**From:** David Latulippe <ddlatulip@aol.com>  
**To:** JF@portlandmaine.gov  
**CC:** BAB@portlandmaine.gov; DReynolds@gorrillpalmer.com; jason.donovan@bangor...  
**Date:** 10/23/2015 1:55 PM  
**Subject:** Re: Prelim comments Re: Marginal Way - Revised Grading Plan

From: Jean Fraser <JF@portlandmaine.gov>  
To: David Latulippe <ddlatulip@aol.com>  
Cc: jason.donovan <jason.donovan@bangor.com>; DReynolds <DReynolds@gorrillpalmer.com>;  
Barbara Barhydt <BAB@portlandmaine.gov>  
Sent: Fri, Oct 23, 2015 11:50 am  
Subject: Prelim comments Re: Marginal Way - Revised Grading Plan

Subject: Re: Marginal Way - Revised Grading Plan

Drawing No.
C102

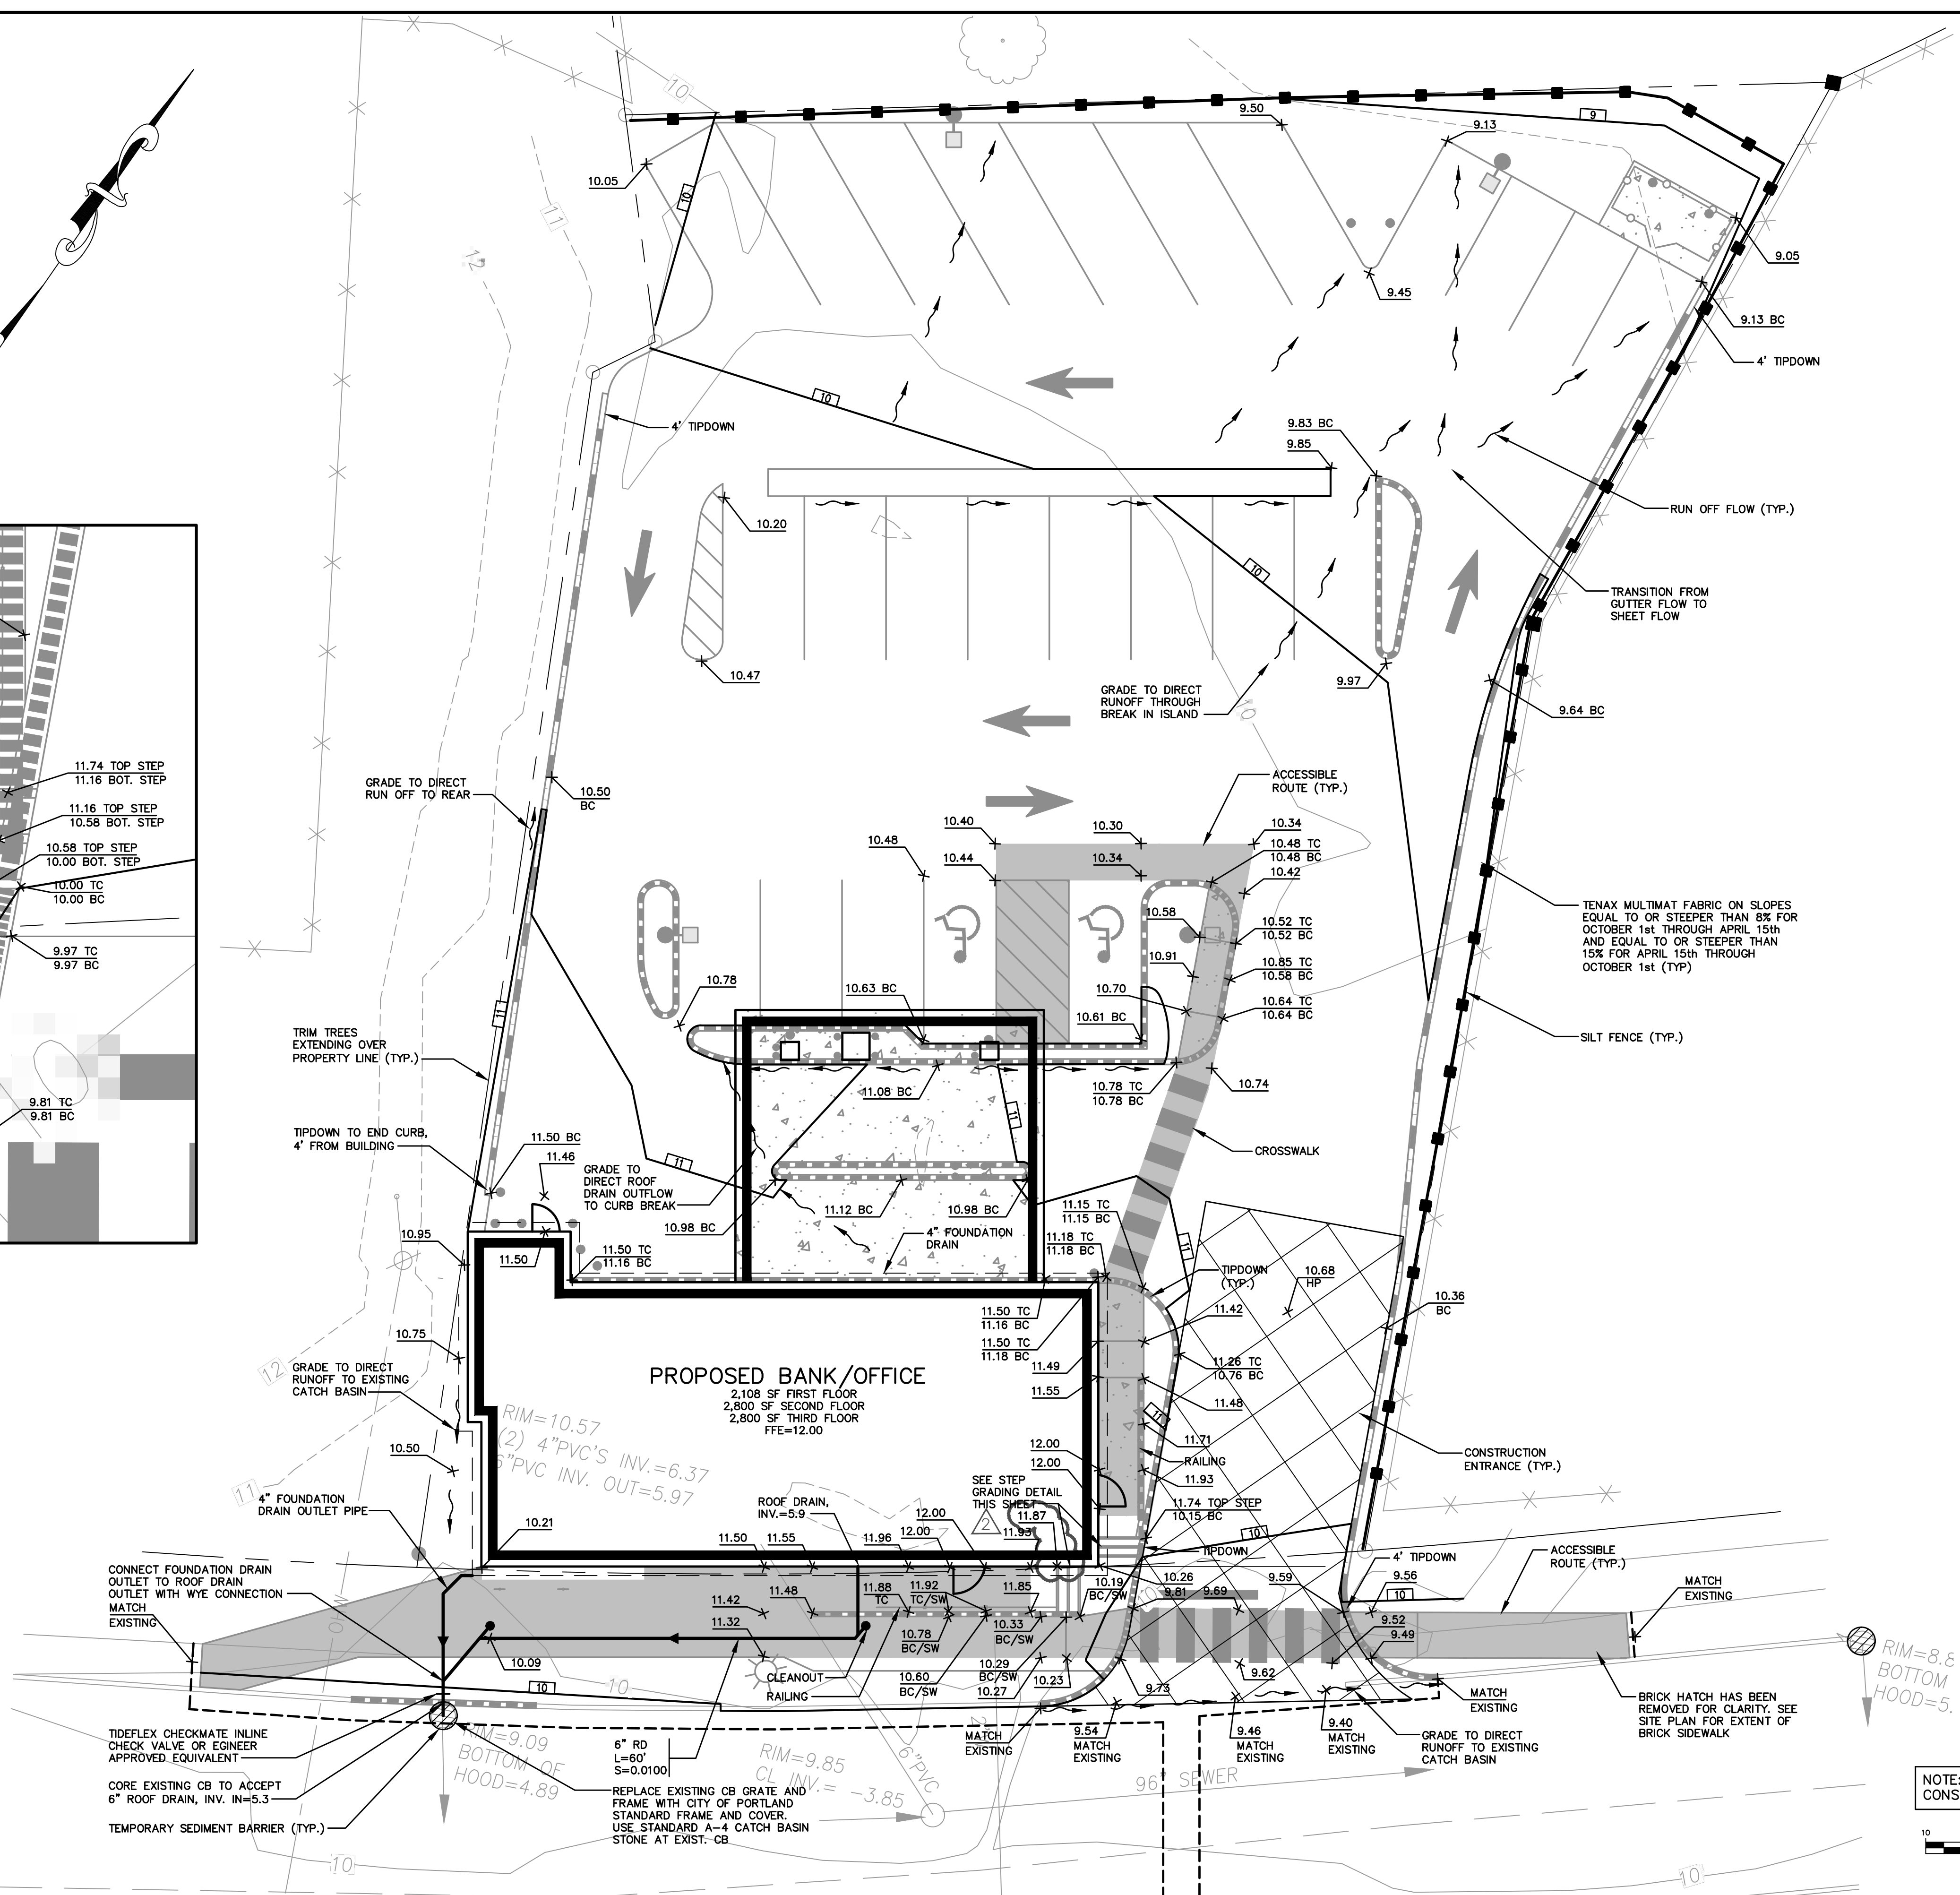
David Margolis-Pineo of DPS suggests that you should go up another foot to be sure of avoiding flooding- you might want to speak with him about that (874 8850).

However, since its in the B7 zone (which has design stds), abuts the Marginal Way Improvement area, and involves a revised entrance design with steps, ramp, railings, low wall and changed sidewalk, we would like to see a cut sheet for the railing and a written description of the materials for all of these elements. Also please confirm that it meets ADA requirements.
